PROVIDENCE PLAZA

FOR PUBLIC HEARING
 PETITION NO. 2005-25

REZONING PLAN

SUBJECT: Administrative Approval for Petition No. 2005-25 Pearson Properties-Cainhoy 1, LLC

RZ-1

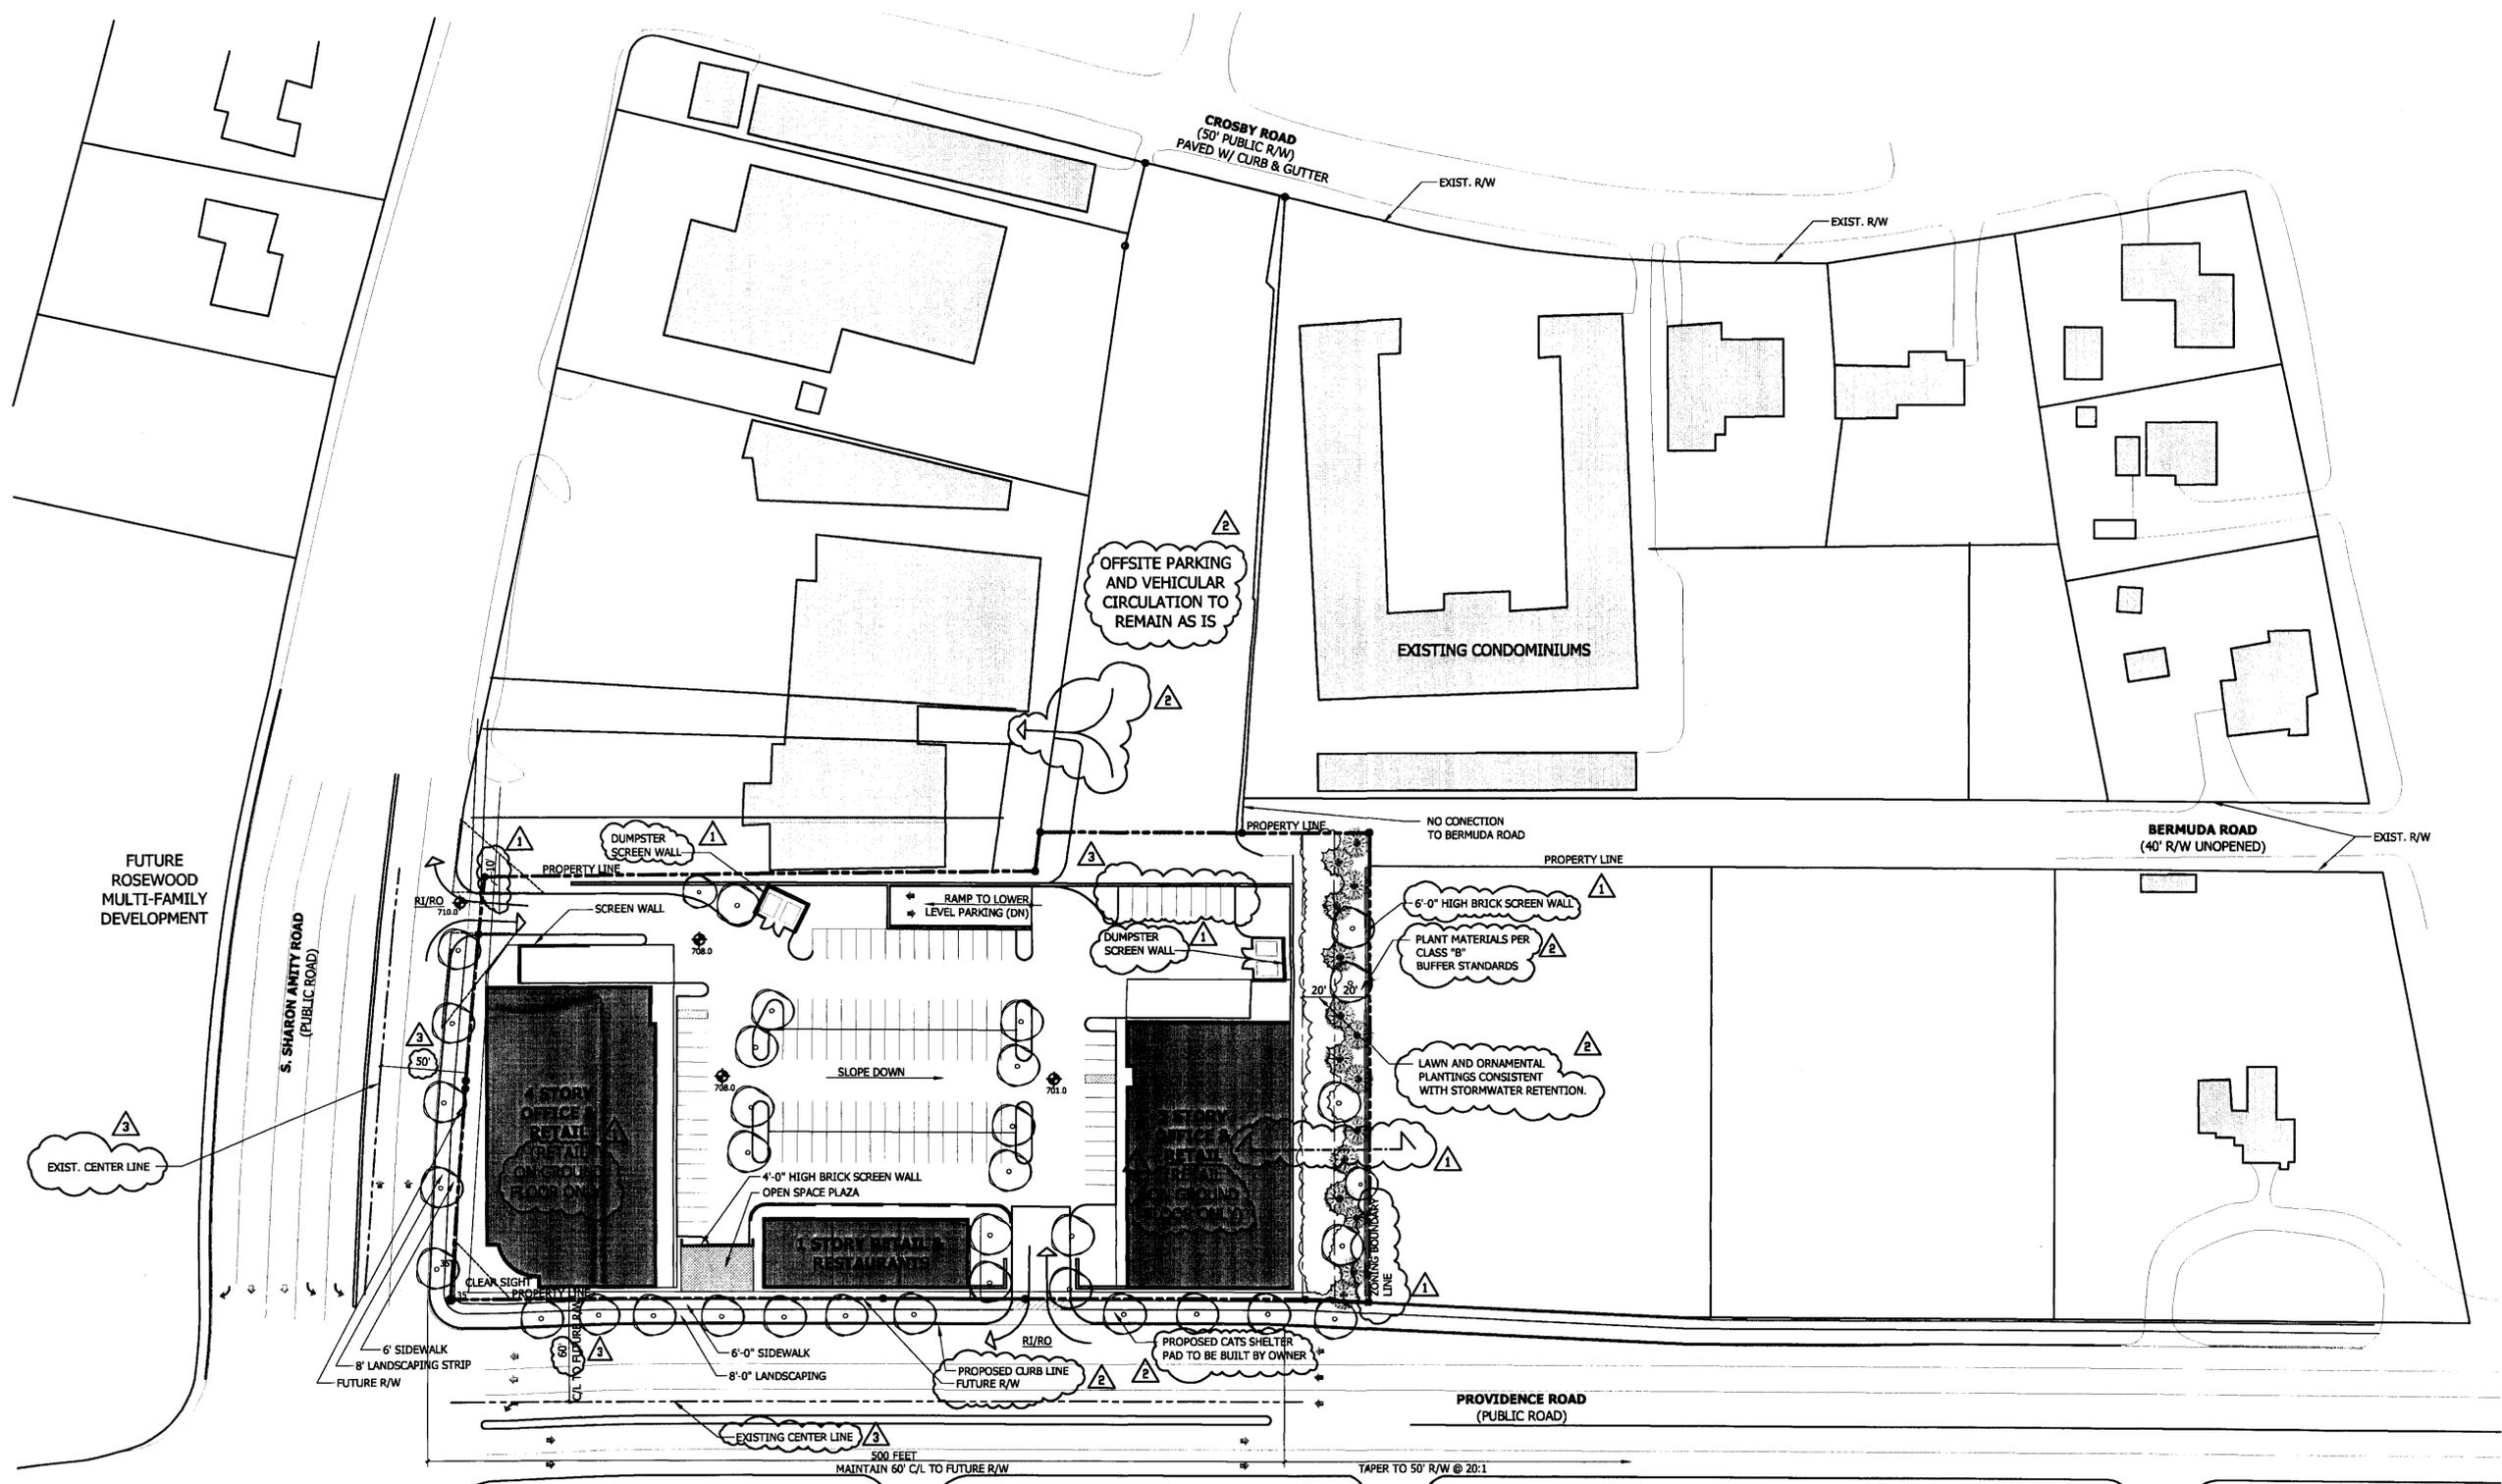
Attached is a revised plan for the above petition. The plan has been revised to show a reduced yard width along the eastern property line, if detention is not required or located underground. Since this change is minor, I am administratively approving this revised plan. Please use this plan when evaluating requests for building permits and certificates of occupancy.
